Planning Application Reference No.: 3/2026/0354

Address of Development: 13 Brookside
Old Langho
BB6 8AP

Comments: Subject: Objections to Proposed Extension

Notes
This drawing is the property of IDC Home Architecture Ltd and copyright is reserved by them. This drawing is not to be copied or disclosed by or to any unauthorised persons without the prior written consent of IDC Home Architecture Ltd.

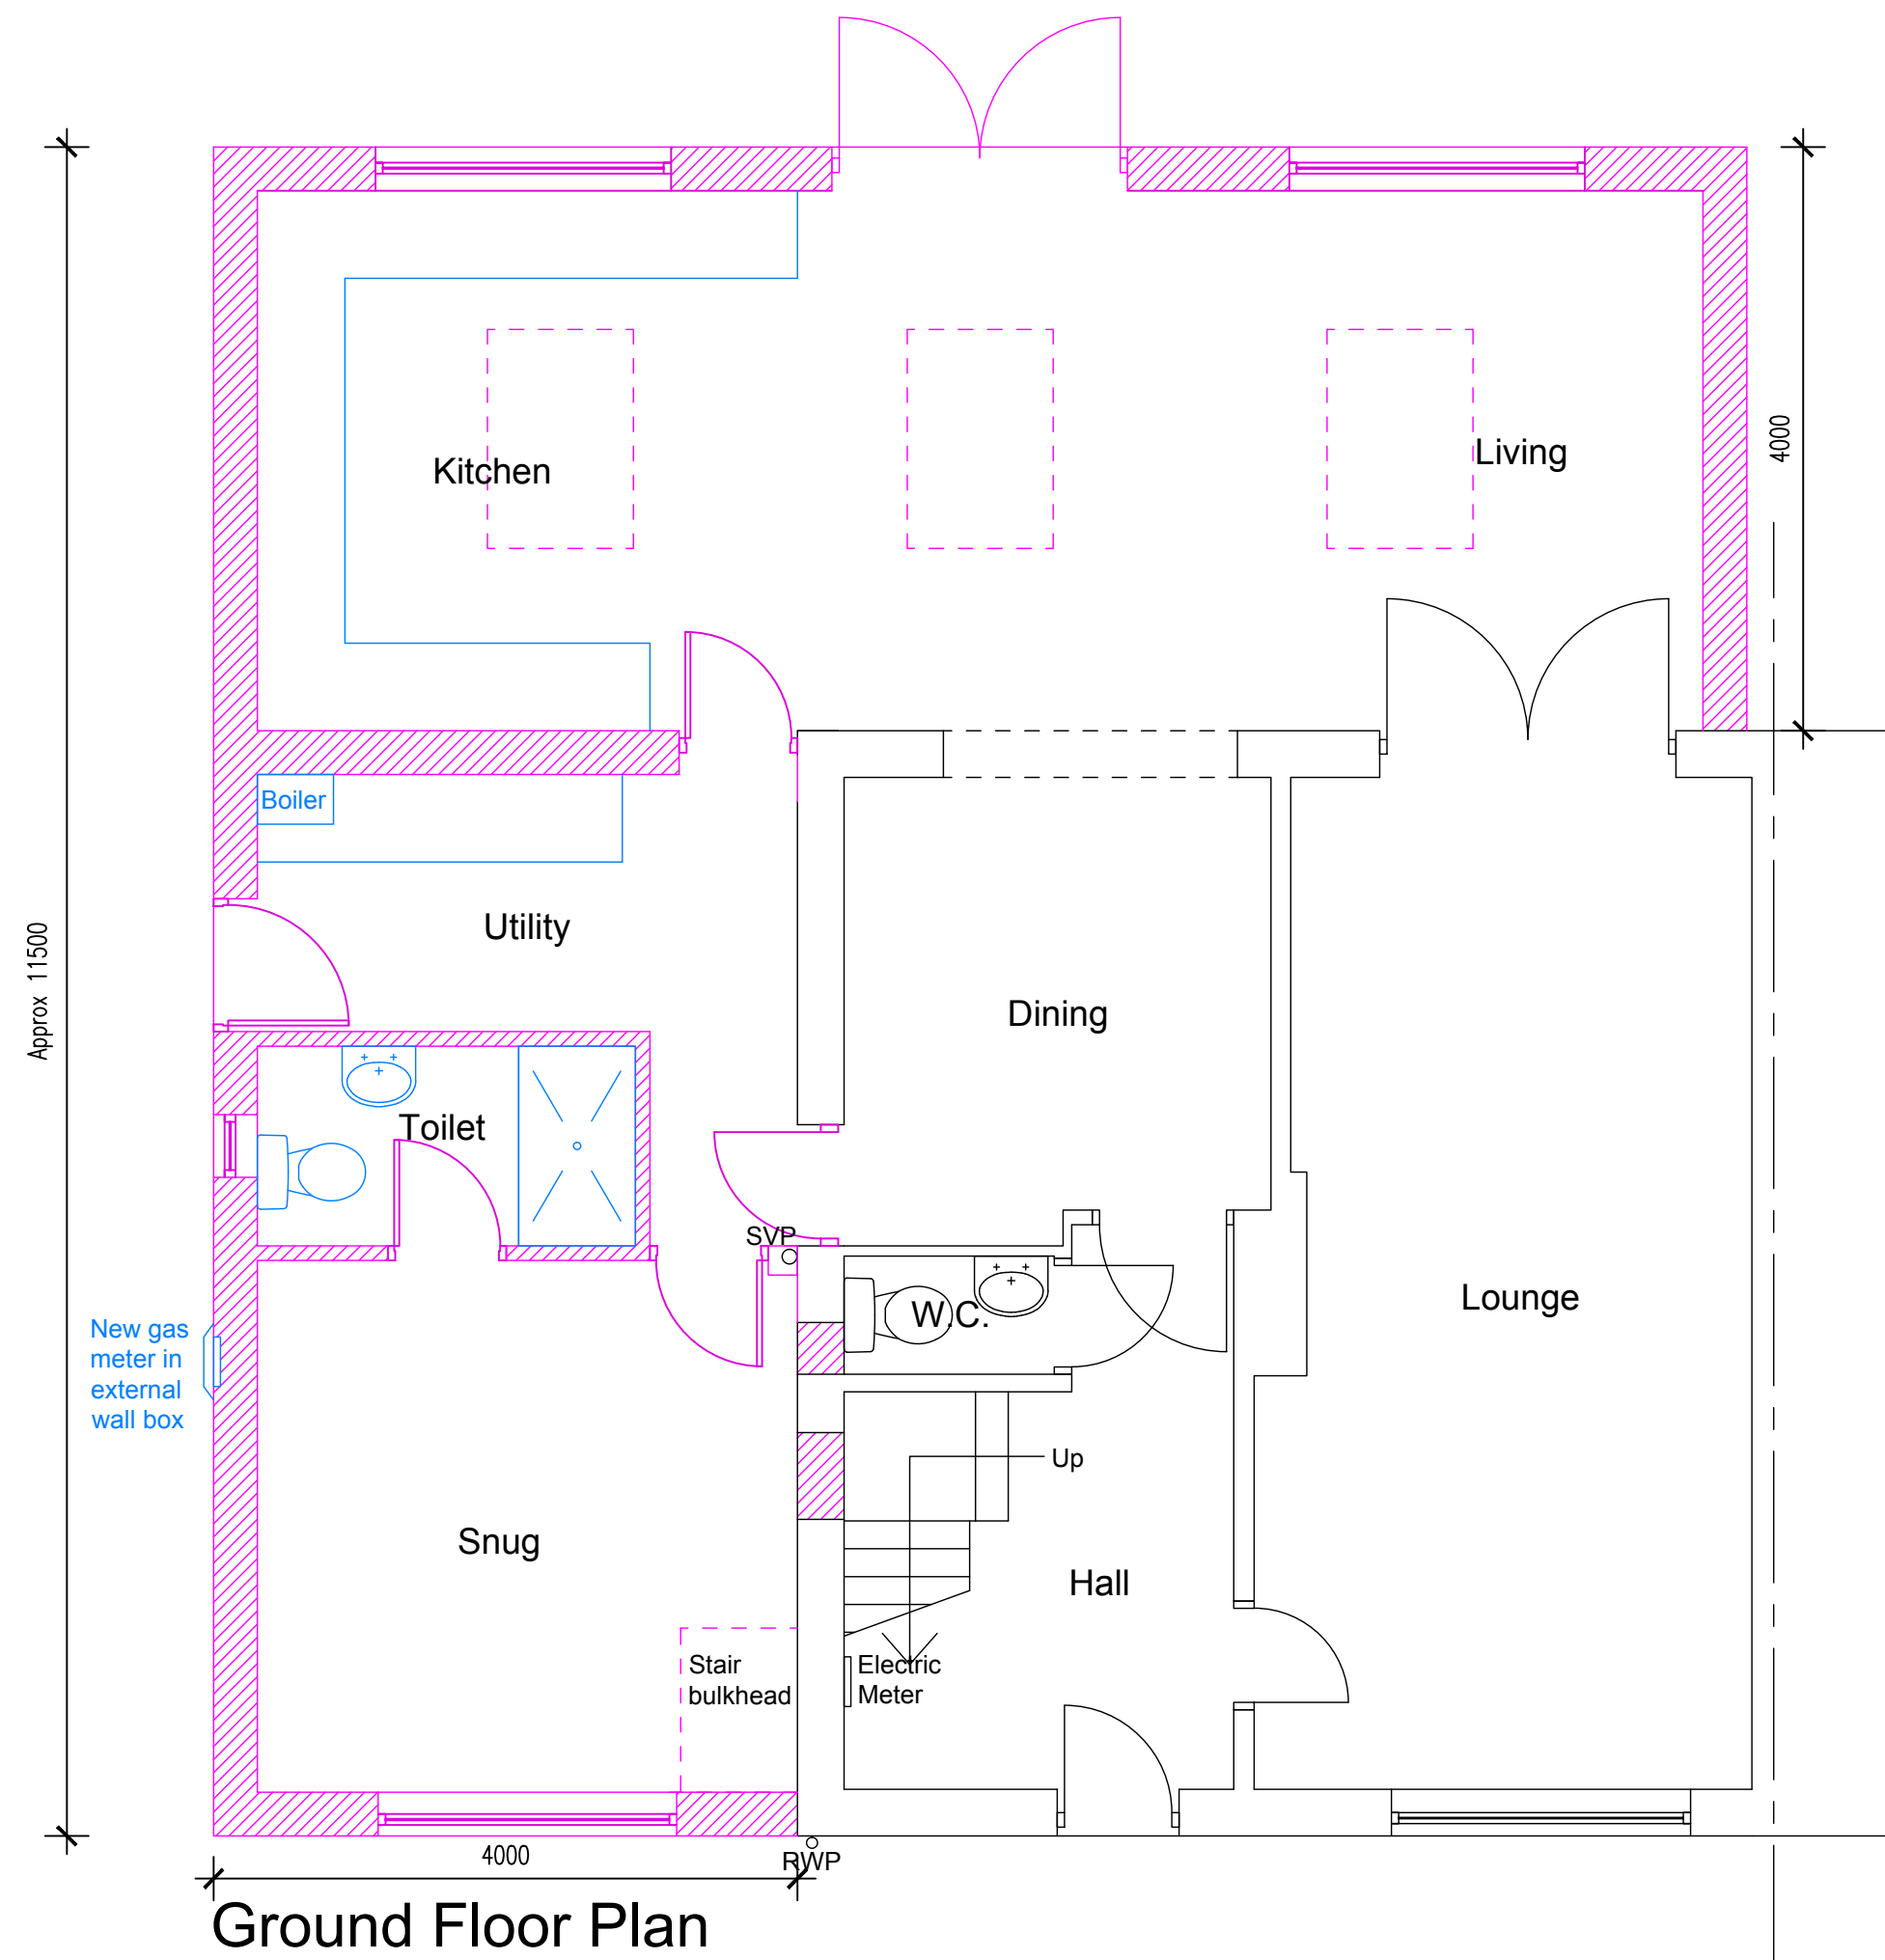
While I appreciate that homeowners are entitled to improve their property, I have concerns regarding both the scale of the proposed development and the impact it will have on neighbouring homes. I am particularly concerned about the proposed first-floor front en-suite window, which would [REDACTED] Given the relatively narrow distance between the houses, this window would result in a significant loss of privacy and allow [REDACTED] The sheer size of a clear glass window as a en-suite in this location would cause a direct and highly intrusive invasion of privacy into [REDACTED] I believe this would be contrary to Ribble Valley Core Strategy Policy DMG1, which seeks to protect the residential amenity of existing neighbouring properties.

As this window serves a non-habitable bathroom rather than a primary living space or bedroom, I do not believe clear glazing is necessary. I therefore respectfully request that, should planning permission be granted, the Local Planning Authority imposes a condition requiring the en-suite window to be in keeping with a normal size bathroom window and fitted with obscure glazing (minimum Pilkington Privacy Level 3 or 4) and to be non-opening below 1.7 metres above the internal floor level, in order to protect the privacy of neighbouring residents.

I have also concerned that the overall size and scale of the extension is excessive for the plot and will have a detrimental impact on the character of the surrounding area. This development appears much larger than neighbouring properties and risks being overbearing.
